Subject: FW: Planning Ref BN66/19/PL Objection

Subject: Planning Ref BN66/19/PL Objection

Proposed Site Masterplan

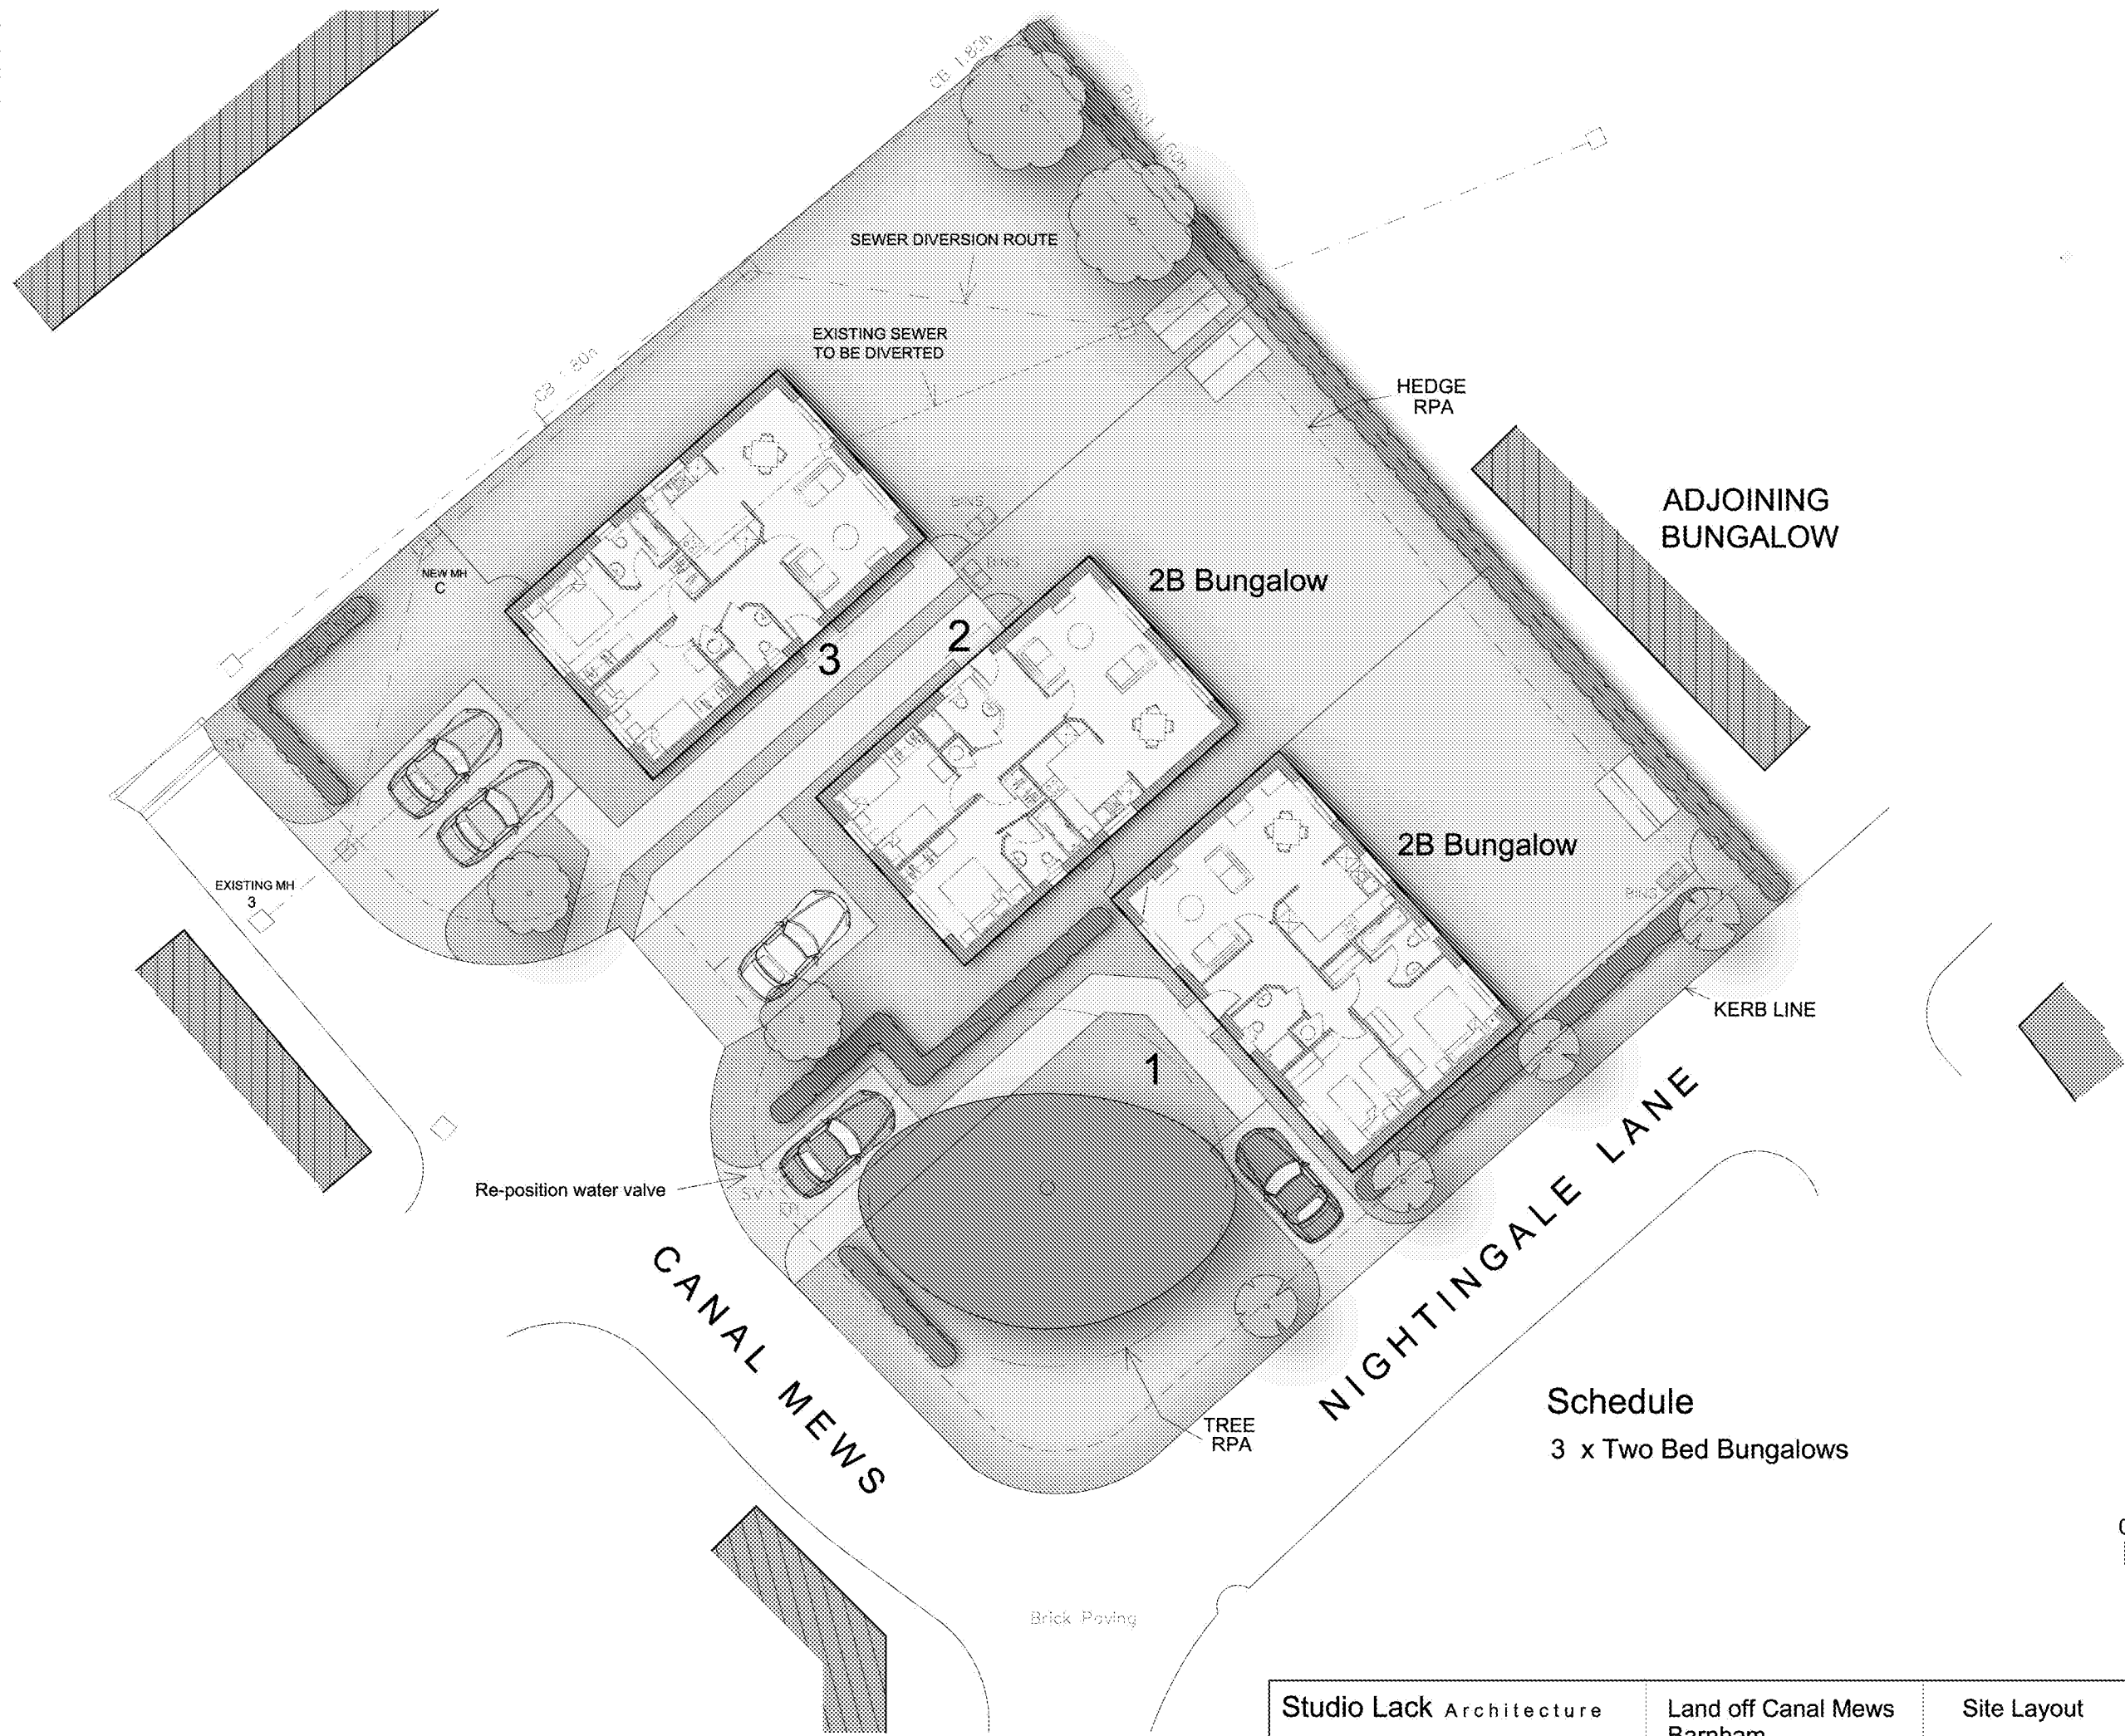
I note on the new site layout submission on the portal that there are no facilities for turning circles for vehicles, as noted by WSCC Highways Authorities. This means that owners of the proposed new properties will be reversing out onto unlit private roads. This raises a Health and Safety issue, particularly as residents of proposed Plot 1 will be reversing out onto a T Junction. This is of serious concern for the safety of both pedestrians and other vehicles. WSCC Highways also comment on access to the plots, and I quote "The LHA advises the applicant to contact the proprietors of Canal Mews and Nightingale Lane to obtain formal approval for the access works on the privately maintained roads" As a resident I have no knowledge of approval being given.

Drainage Strategy Drawing

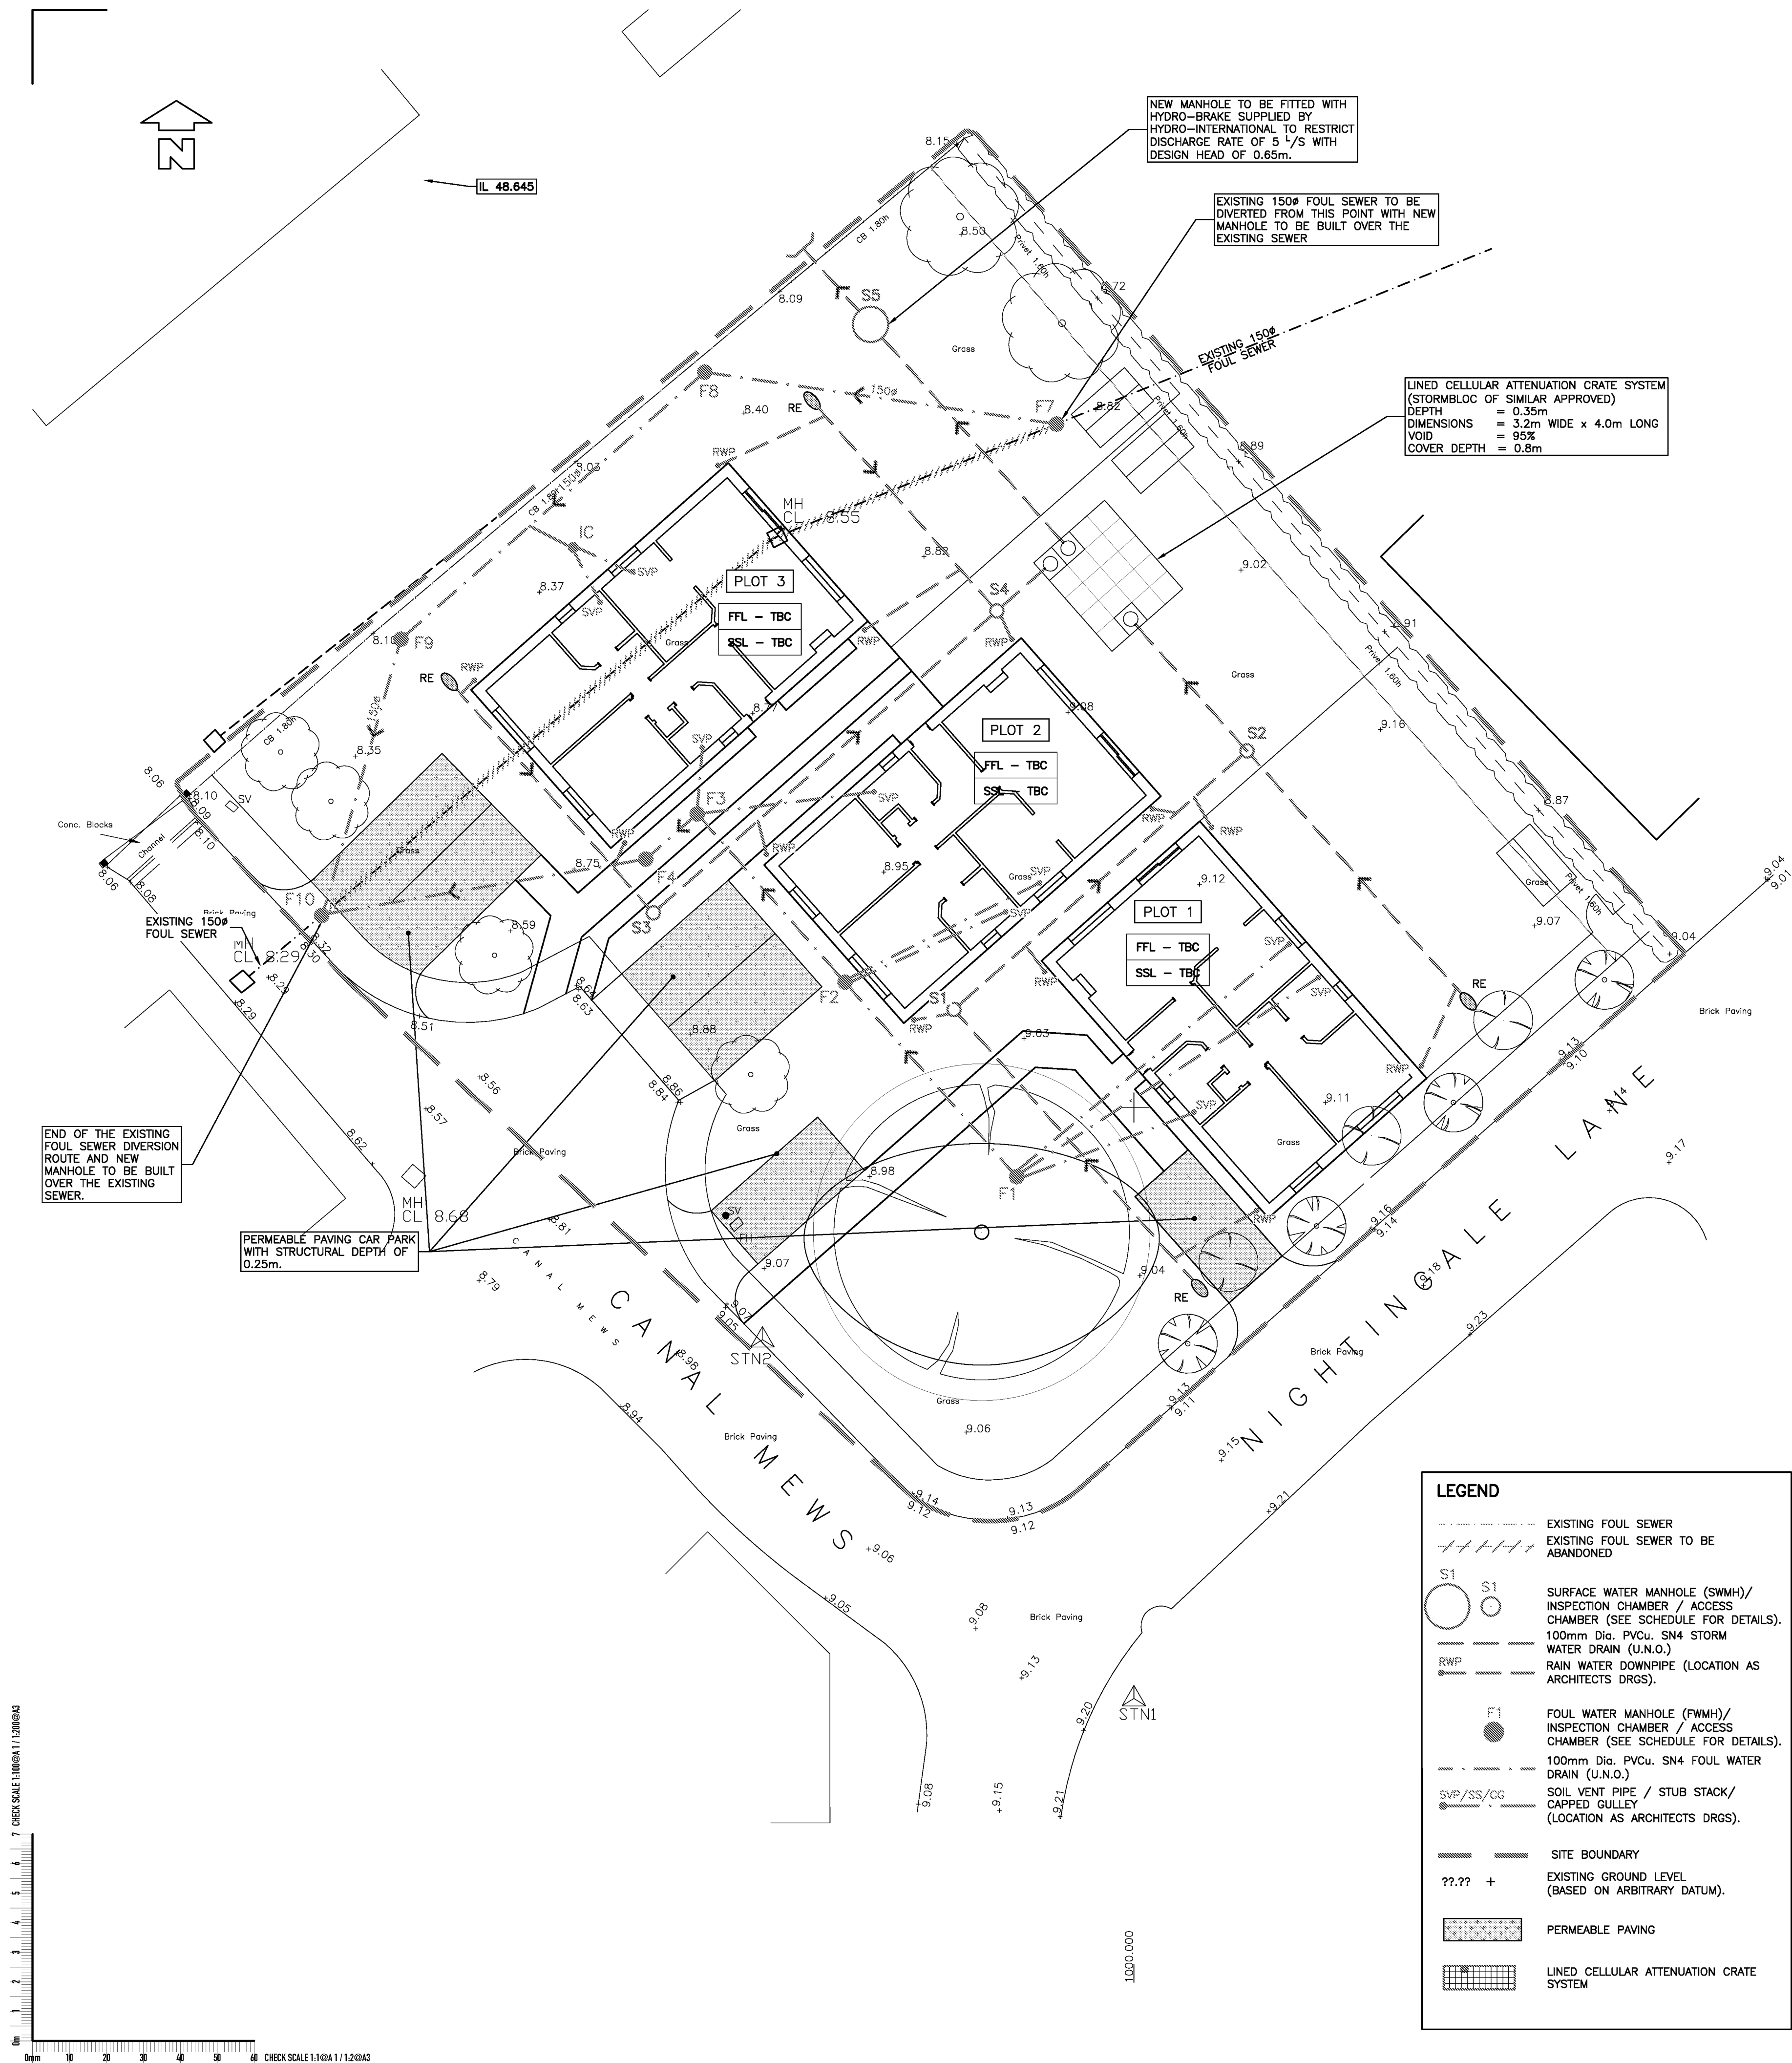
The red arrows show sewerage pipes converging in the centre of the proposed site. The green arrow shows approximate area where the sewerage outlet pipe is which connect to Southern Water. It is imperative to note that these sewerage pipes are private. Seaward have no authority to move/divert them. They also have no authority to connect up to them for the purpose of their development. There is also the question of whether there is a holding tank under the site in place of the previously proposed treatment works? There have been historic issues with some of the sewerage pipes on Arun Place. Adding 2 further properties to the current stepped sewerage system will only

increase the load on the system which is already at capacity. In addition, proposing 4 turns in the system will increase resistance and make the existing pipes more prone to blockage.
